Engineers Comments Regarding Surface Water Drainage

Application Reference:	WA/22/26/HH	Reviewer Reference:	ADC/JD/KW
Planning Officer:	Silvie Steiningerova	Date of Review:	30/04/2026
Site Name:	The Old Vicarage The Street Walberton BN18 0PQ		
Application Description:	Construction of oak framed car port and associated works. (This application may affect the character and appearance of the Walberton Village Conservation Area).		
Assessment Number:	1

Flood Risk Assessment

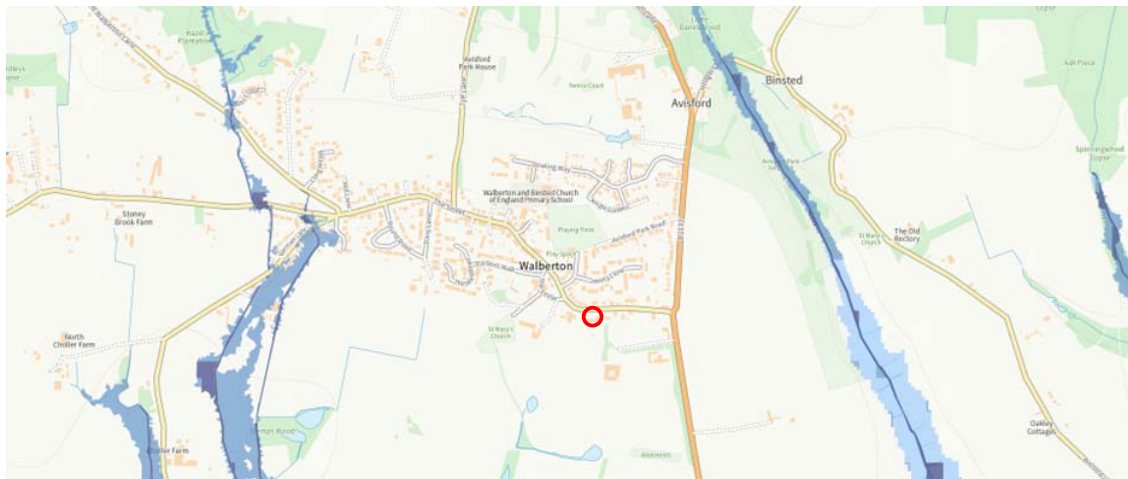
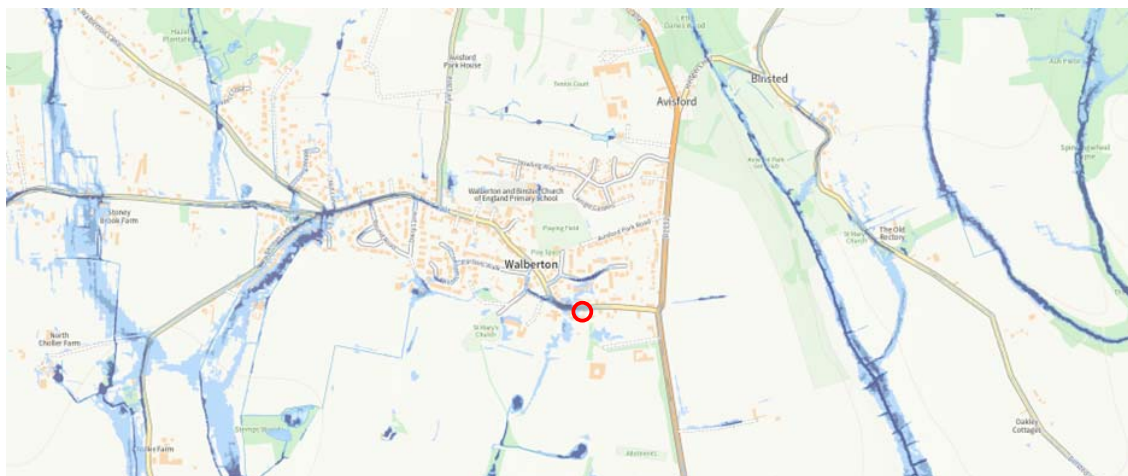
3.1. The northern boundary of the site sits in an area at a medium-high risk of surface water flooding. The majority of the front driveway area where the proposed carport will be sits in an area of low risk of surface water flooding, falling into the 0.1% Annual Event Probability (AEP). When Climate Change is considered, the area where the carport is to be placed increases to be at medium risk (1% AEP). This may need to be accounted for by the surface water drainage design. The design may need to account for additional surface water volume entering the site from elsewhere and ensure that levels are not altered. For further guidance, please refer to our SuDS in Flood Areas document available online at www.arun.gov.uk/surfacewater.

3.2. At present, no modelling or supporting evidence; such as ground investigations or drainage plans have been submitted for engineering assessment. In the absence this evidence, we cannot assess if flood risk will be increased by the surface water drainage of the proposed development. Therefore, this application does not accord with the NPPF as set out above leading us to **object**.
